KITITITAS COUNTY

MEMORANDUM

TO: All Staff
FROM: Public Works Planning Review Team
DATE: December 7, 2020
SUBJECT: BL-20-00027 Pine View Estates

BOUNDARY LINE ADJUSTMENT BL-20-00027
 PREPARED FOR
 KEVIN KELLY
 A PORTION OF THE EAST 1/2 OF SECTION 6,
 TOWNSHIP 19 NORTH, RANGE 16 EAST, W.M.
 KITITAS COUNTY - WASHINGTON

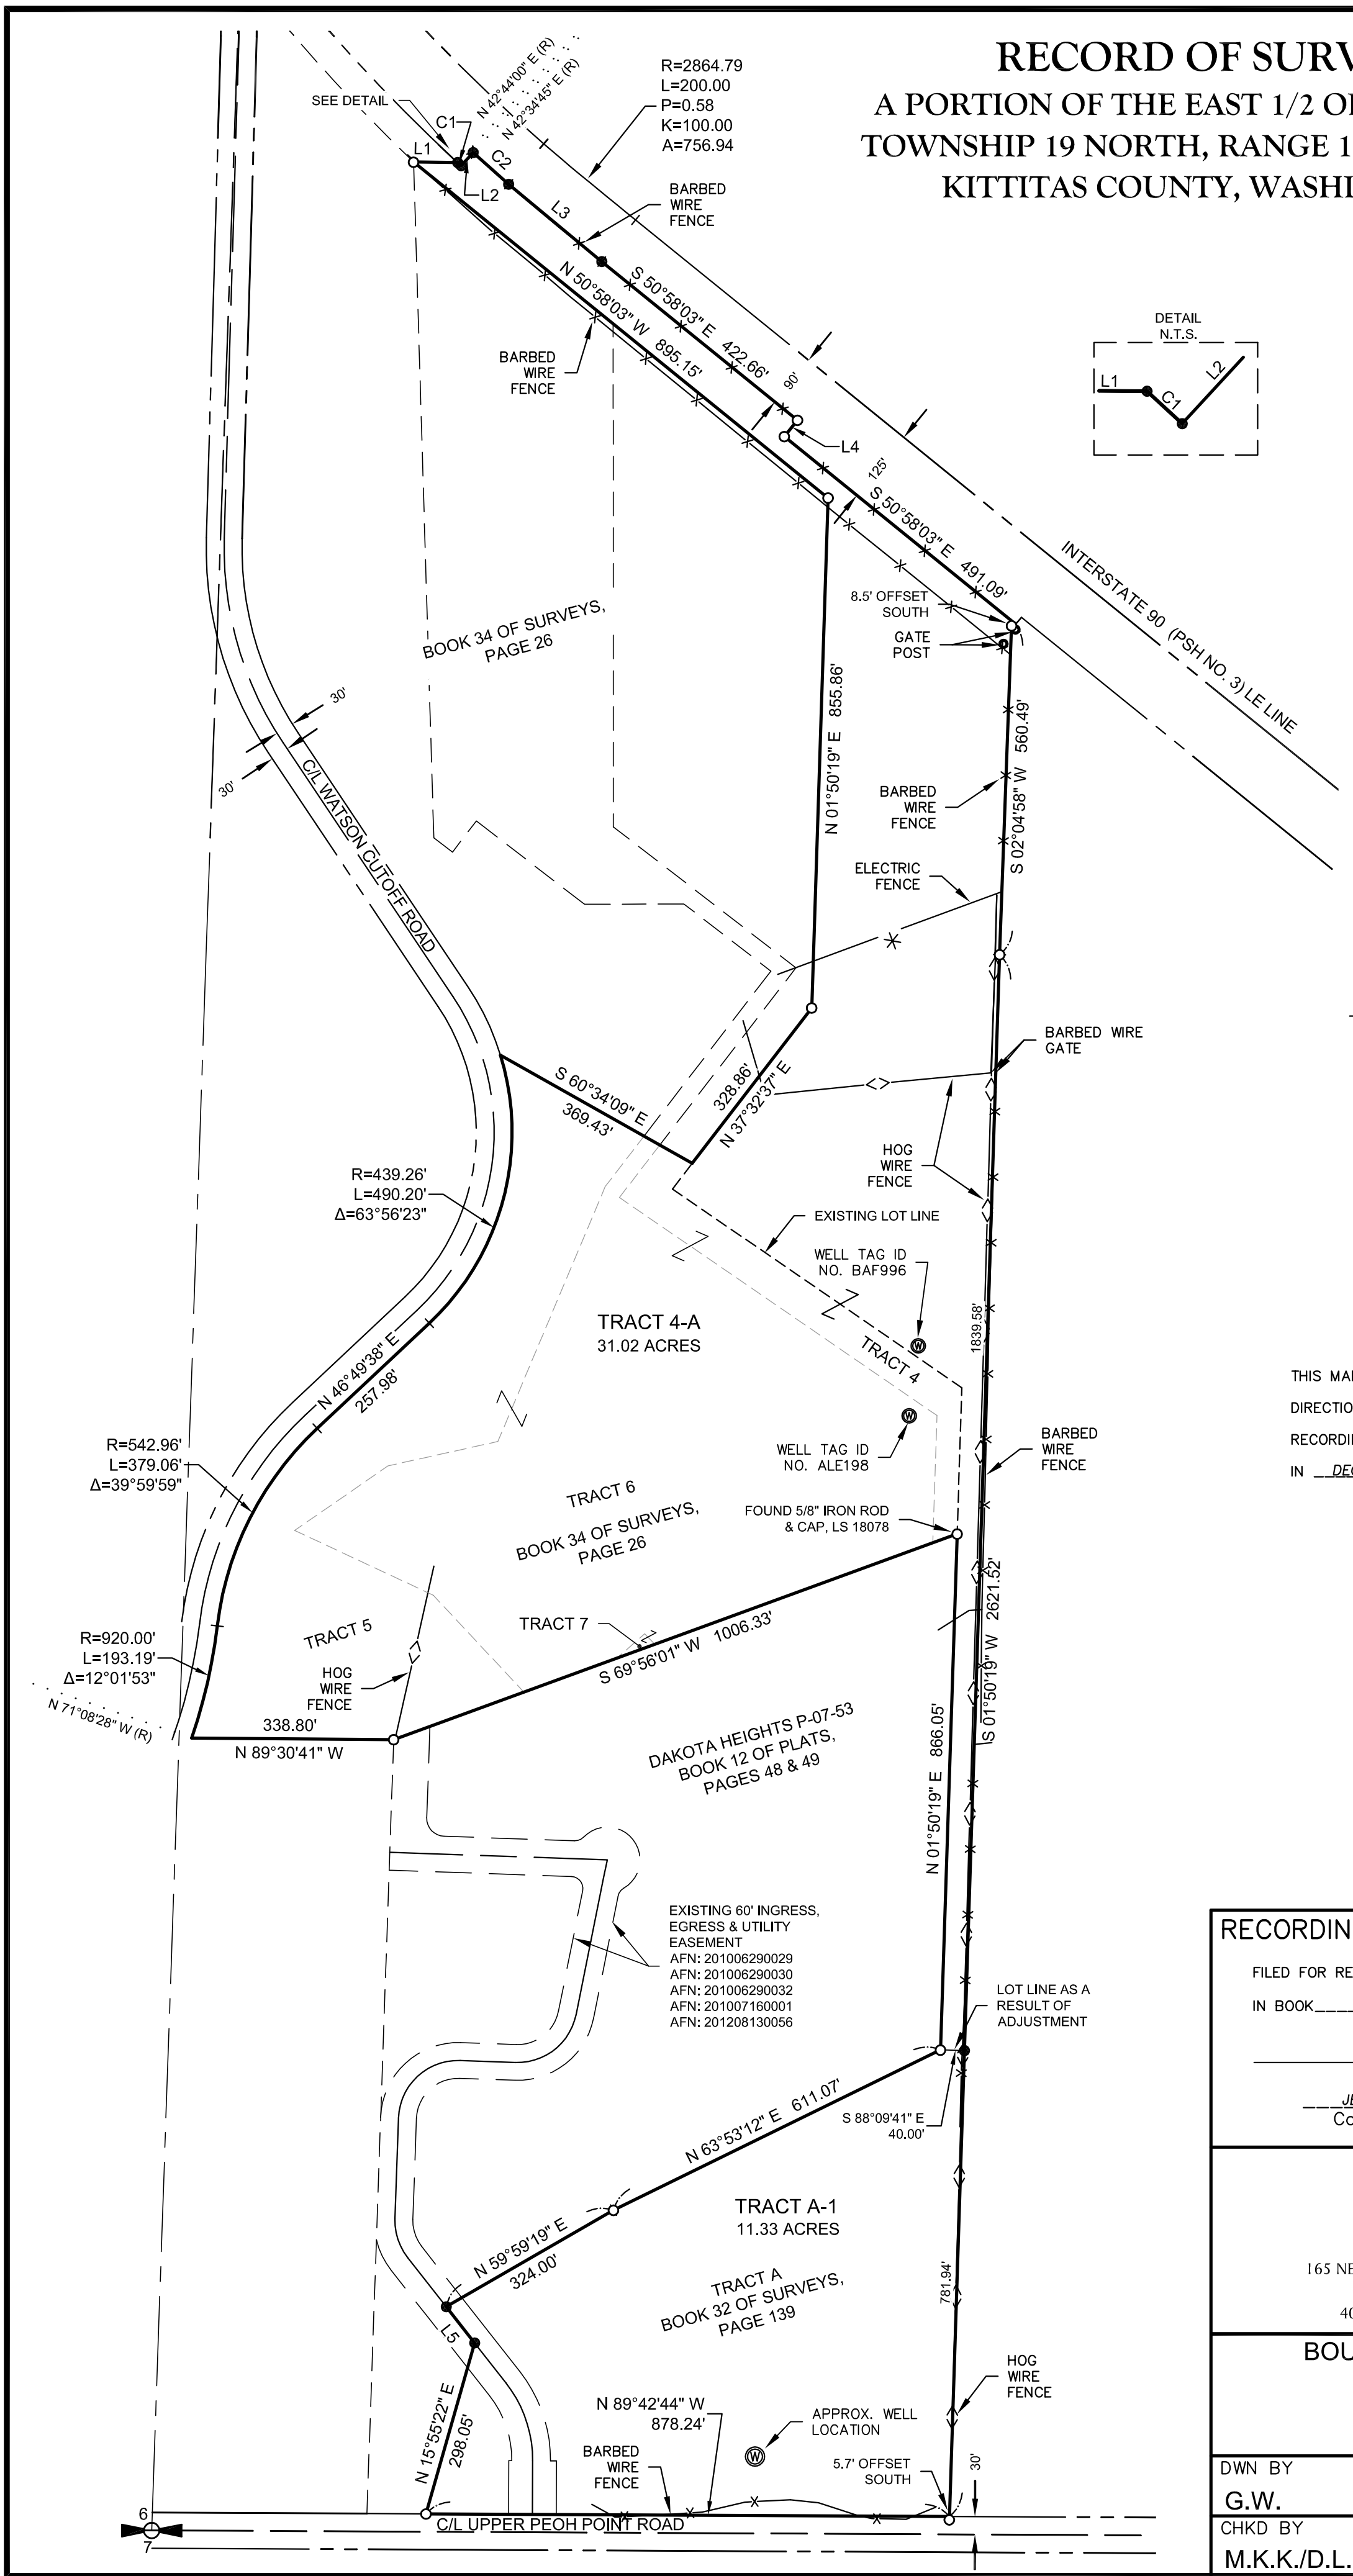
1. A revised legal description that describes the final configuration of the subject property shall be required.
2. A survey map for review. Any comments for survey will be reserved for final.
3. Show access easements on the face of the BLA.
4. Of note: Parcel 960356 would need to apply for an access/address permit prior to building.
